2022/0486

1 Woodroyd Gardens, Wombwell, Barnsley, S73 0HB

Erection of detached garage

BLOCK PLAN

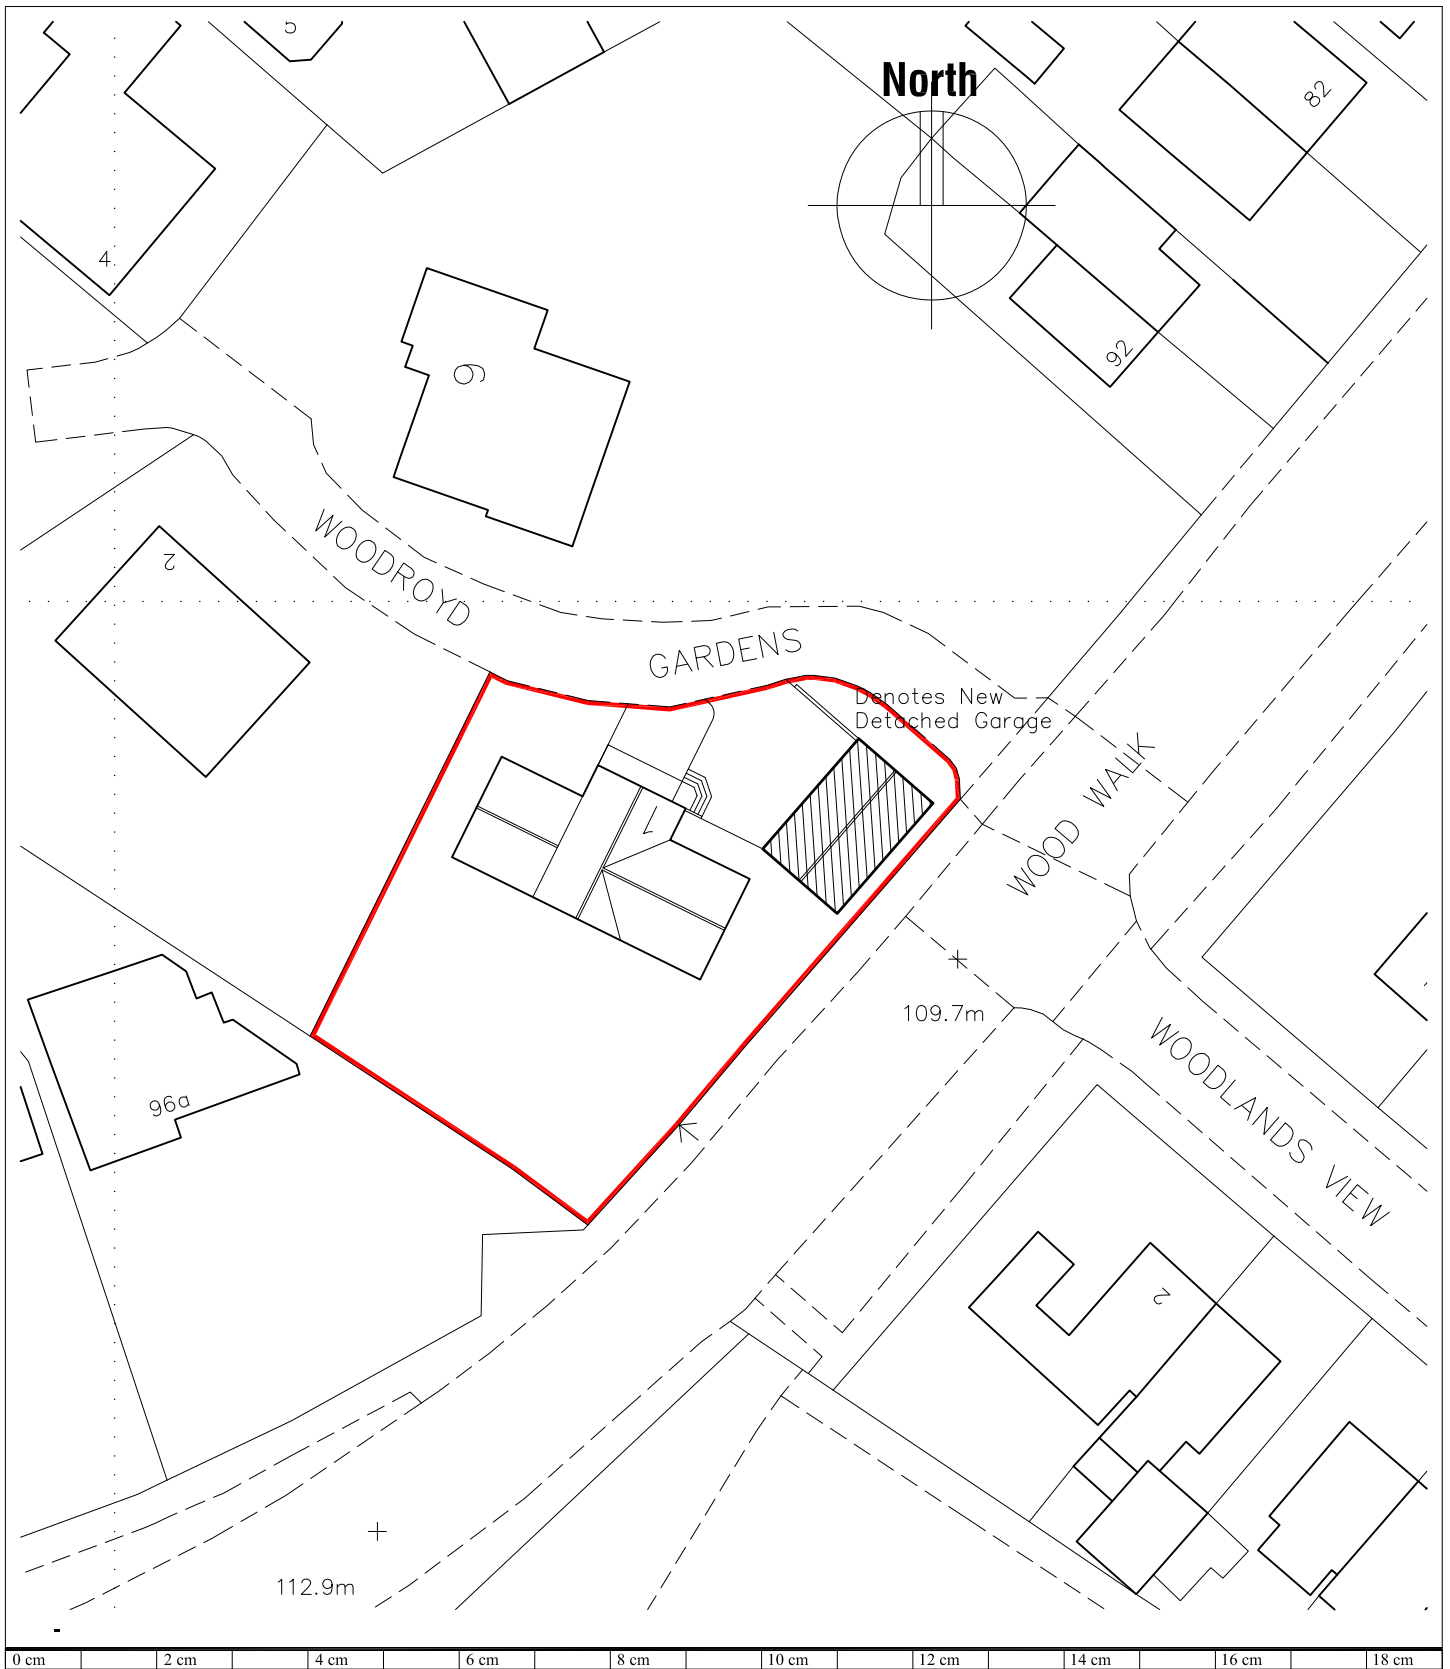
Having looked at the plans I do still have concerns over the incremental development of this site and the impacts this will have in terms of the protected trees. I fully appreciate the efforts of the arboricultural consultant to specify acceptable solutions, but the inescapable fact is that almost the entire rooting areas of these trees will be surfaced over by either the concrete slab on top of the pile and beam foundations and the permeable paving.

BS5837:2012 notes that new hard surfacing should not occupy more than 20% of the trees current uncovered rooting area; it is clear from the plans that what is proposed is far in excess of this particularly when considering the area effectively covered over by the garage itself.

I do not feel therefore that the application can be considered acceptable in arboricultural terms given that the works will cover almost the entire rooting area of the trees disrupting the rooting environment to the detriment of the protected TPO trees.

The entire rooting area of the trees will be surfaced over by the proposed development. There are also concerns about the cumulative effect on the trees from the continual disturbance and development on the plot. Given the protected status of the trees it is judged that the cumulative effect of the continual development of this property along with the new garage and large hard surfaced area would have a detrimental impact on the trees. Ultimately covering of the entirety of the useable ground for the tree's roots is unacceptable and would ultimately be detrimental to the long-term health of these protected trees. The proposed development is considered to be contrary to the Council's SPD for Trees and Hedgerows and Local Plan Policy D1: High Quality Design and Place Making and is unacceptable in terms of its impact upon the trees immediately adjacent to the site.

Plans, Elevations & Section.

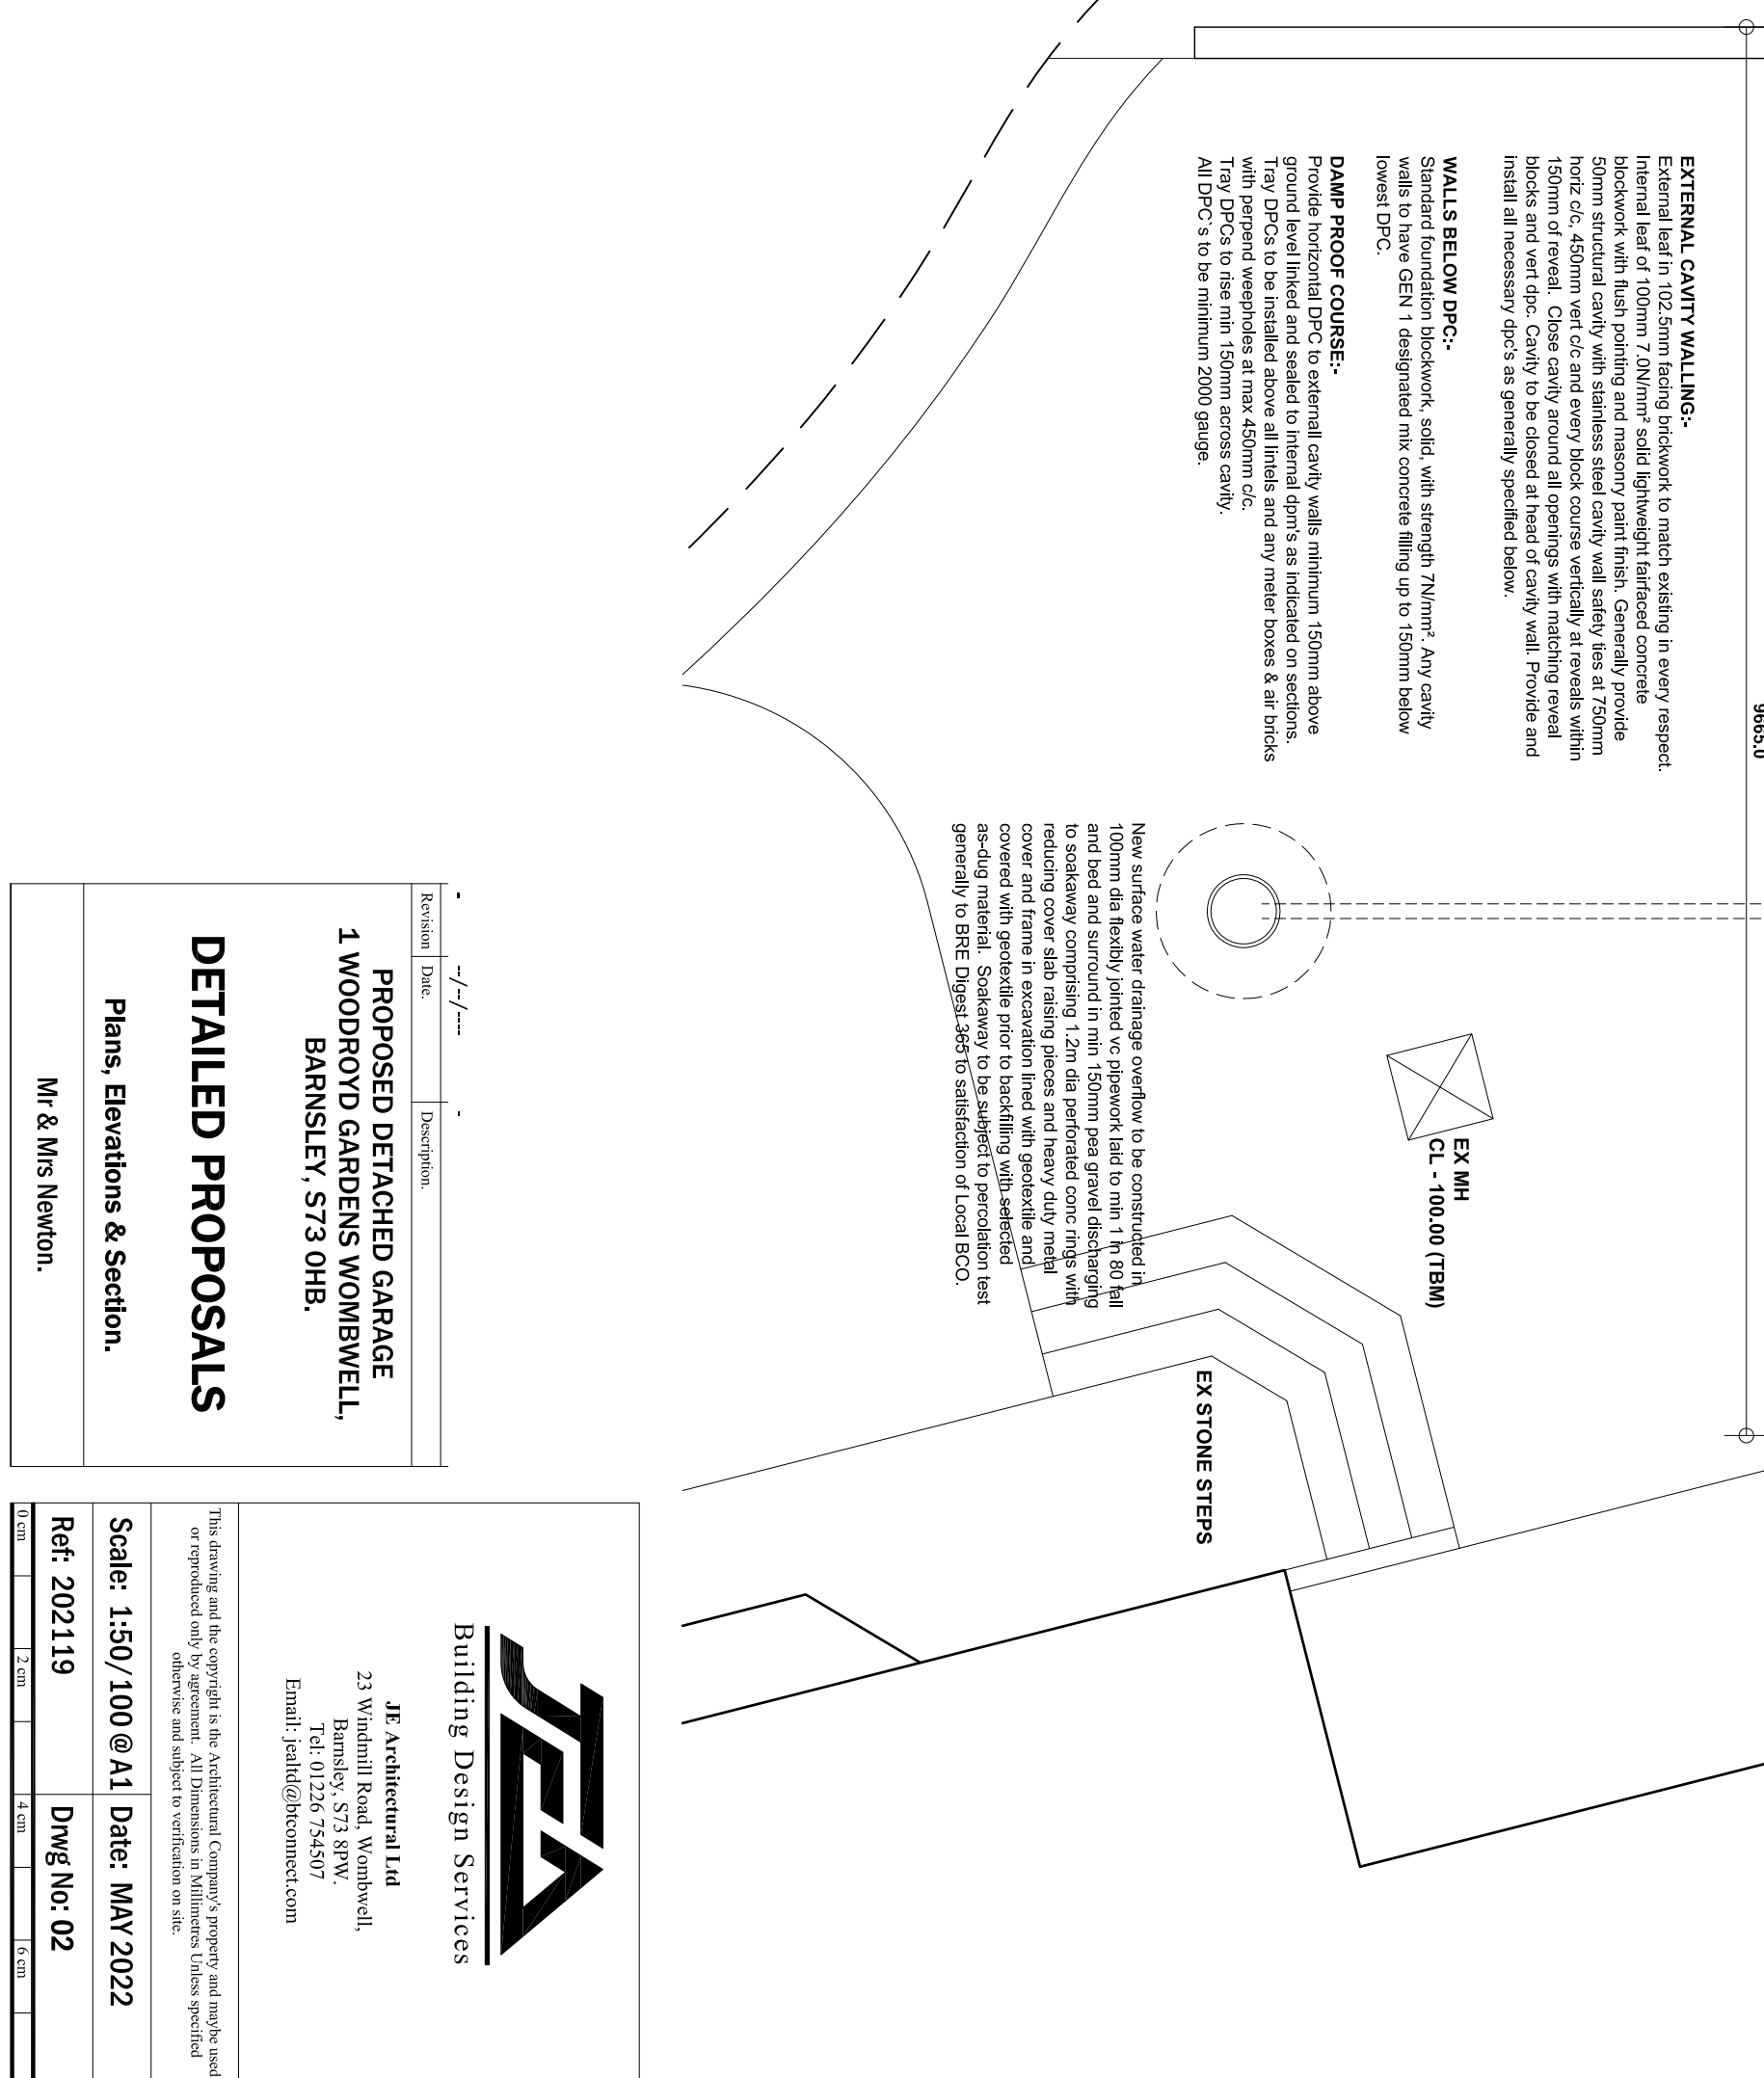
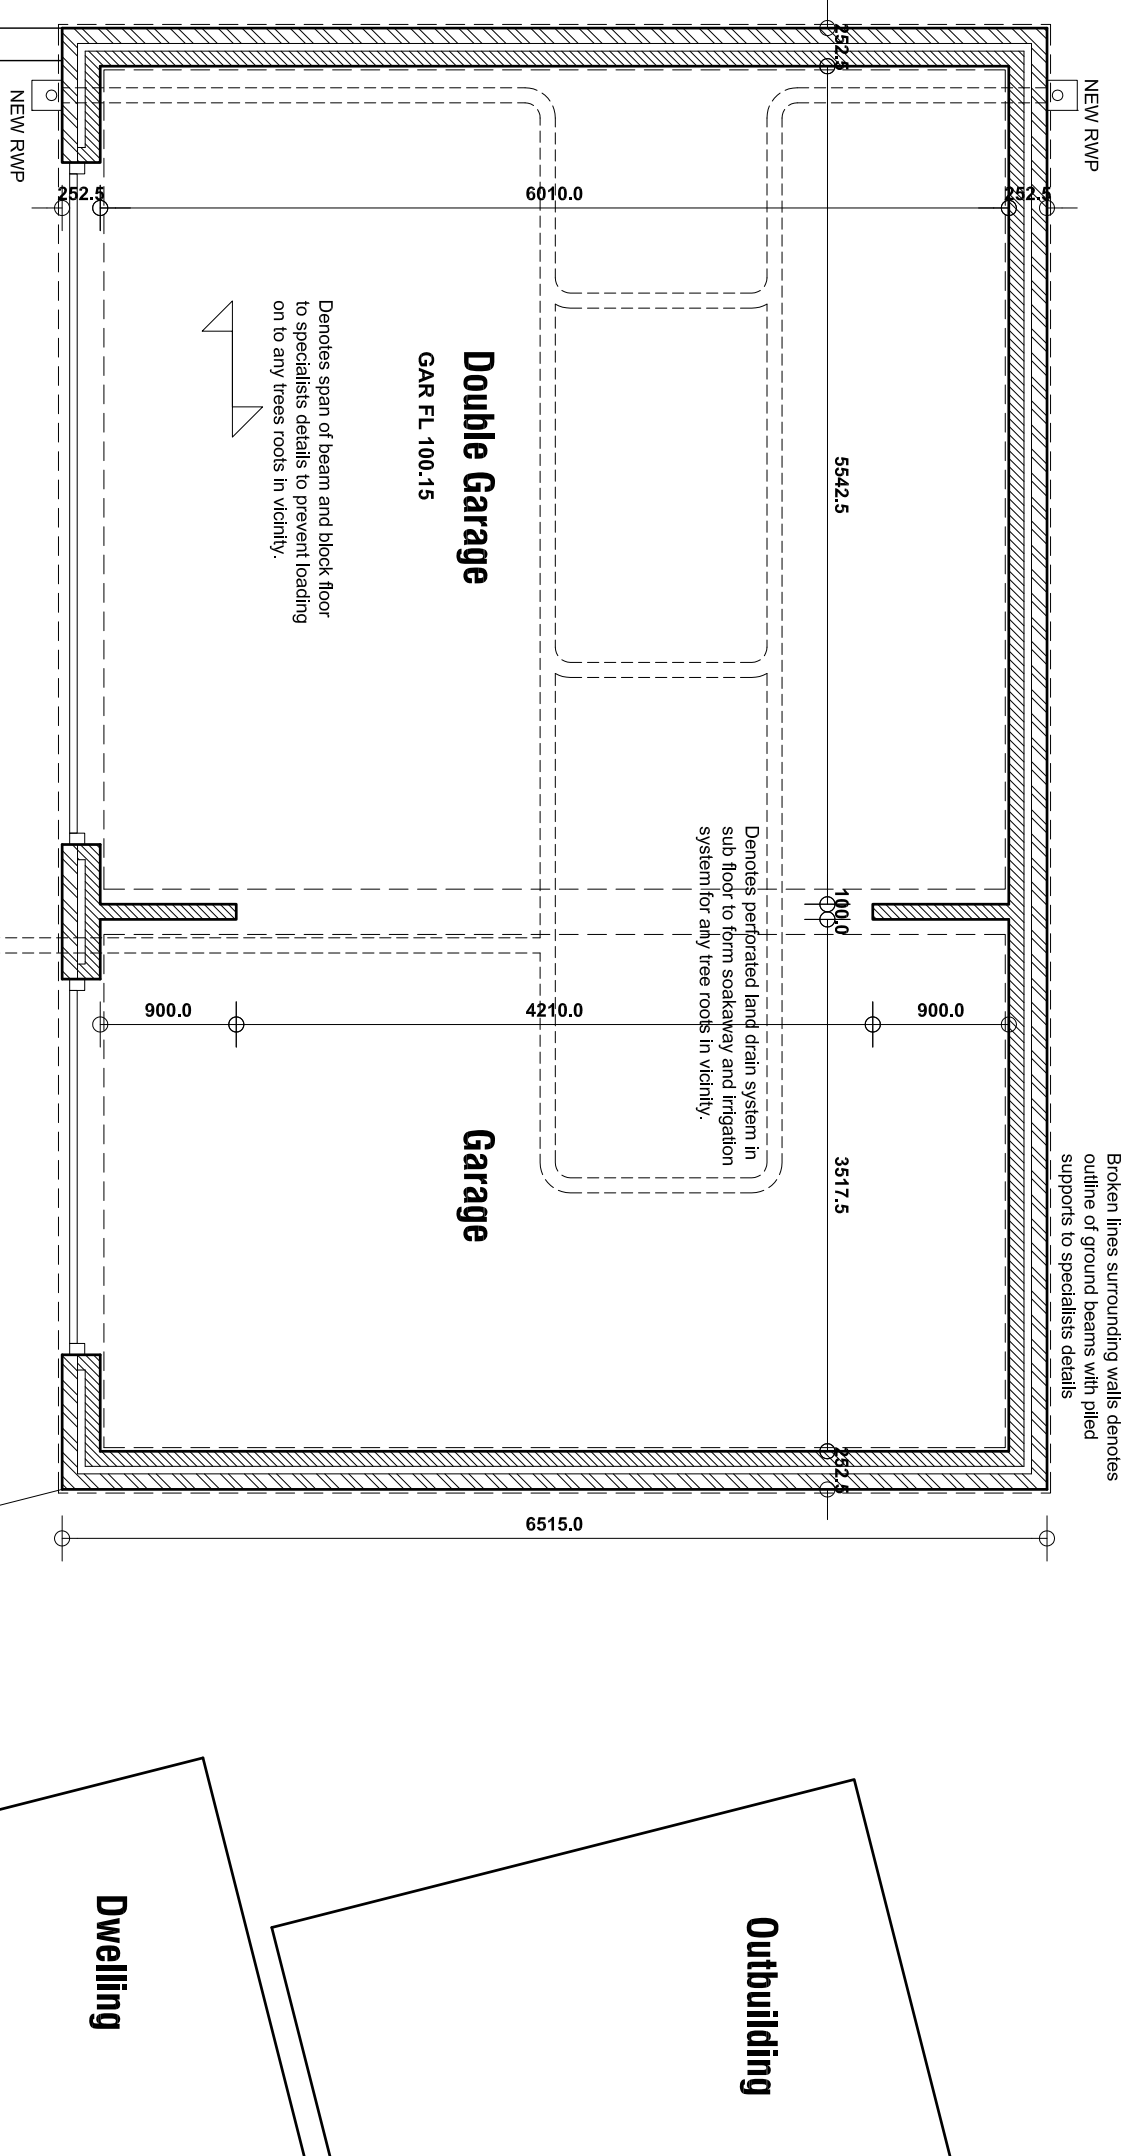
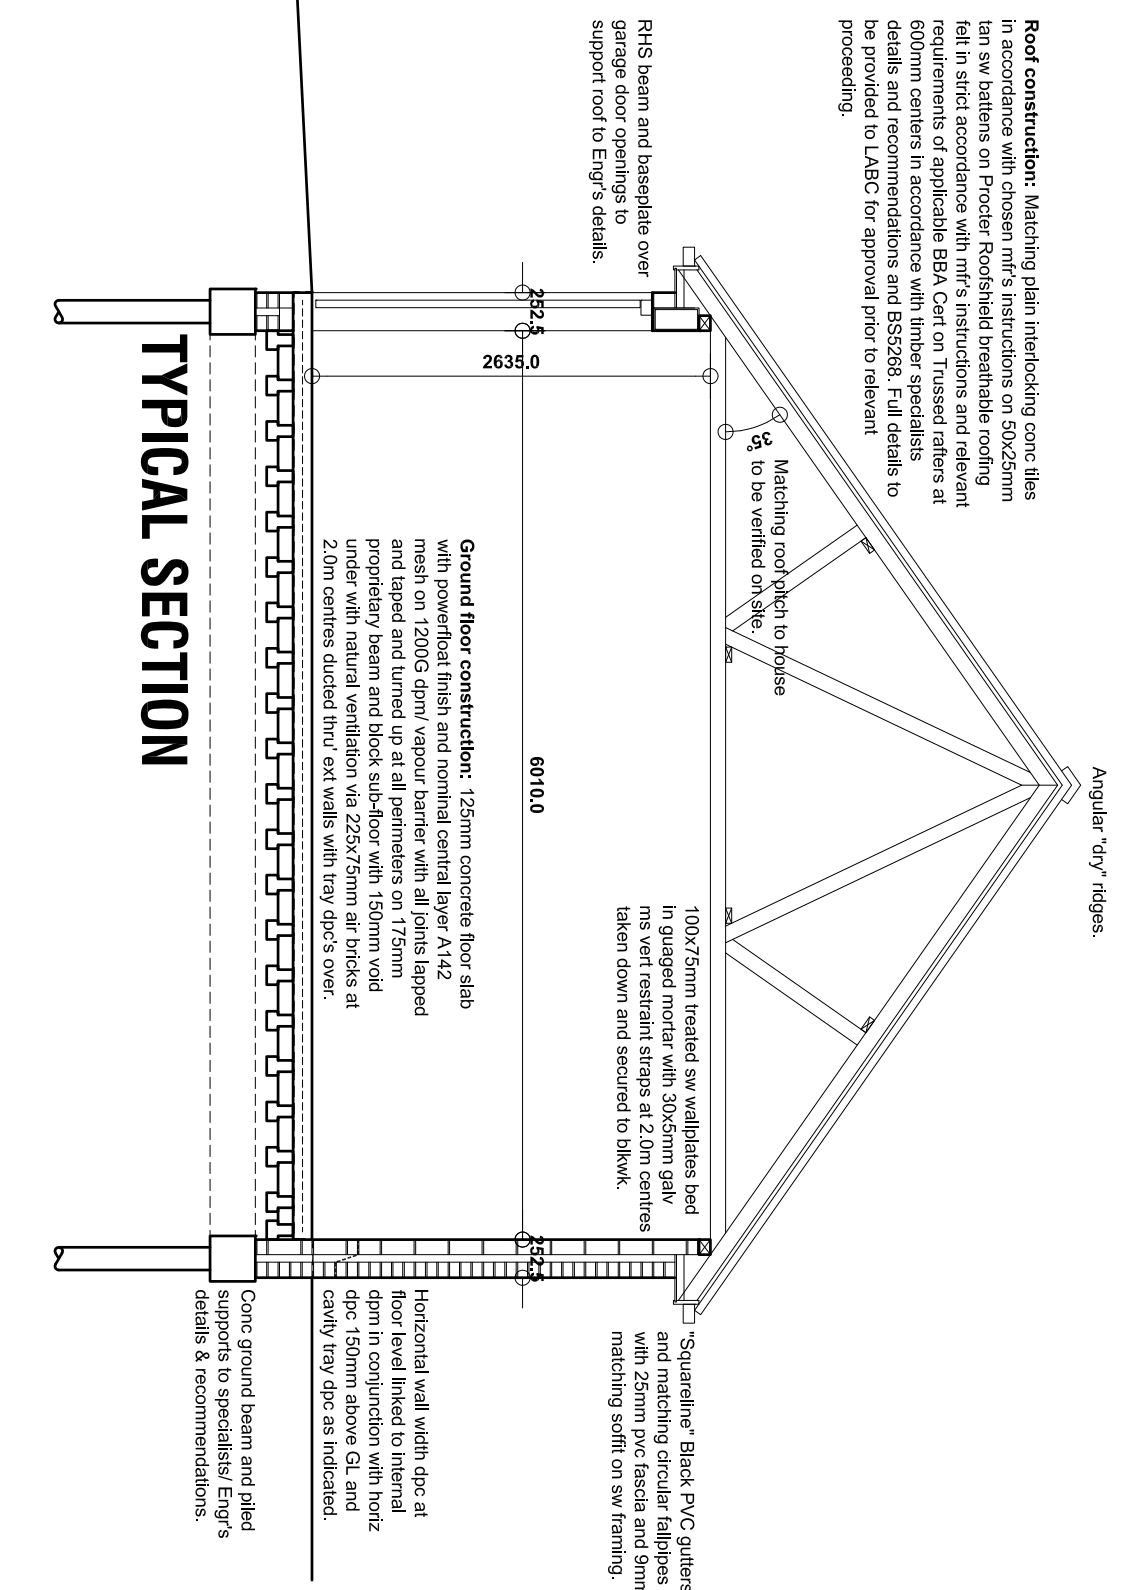
The SPD states that *"detached garages should relate sympathetically to the main dwelling in style, proportions and external finishes. In most cases, it will not be appropriate for a garage to be sited between the house and the road"*. In this case the dwelling is sited between the host dwelling and the road which considering that the dwelling is the first on Woodroyd Gardens when viewed from Wood Walk exacerbates the impact of it being set forward of the host dwelling. The garage also draws the eye due to its proximity to the highway in relation to the host dwelling and the proposal would cause the garage to further dominate the street scene.

Therefore, it would appear as an abnormally large garage and an anomalous feature in the street scene, therefore incurring substantial harm to the visual amenity of the area. Also, the proposed height of the garage is likely to diminish its ancillary appearance to the main dwelling and expand its capacity to house an annex, henceforth not being subservient to the existing dwelling. The proposed development is therefore considered to be contrary to Local Plan Policy D1: High Quality Design and Place Making and is considered unacceptable in terms of visual amenity.
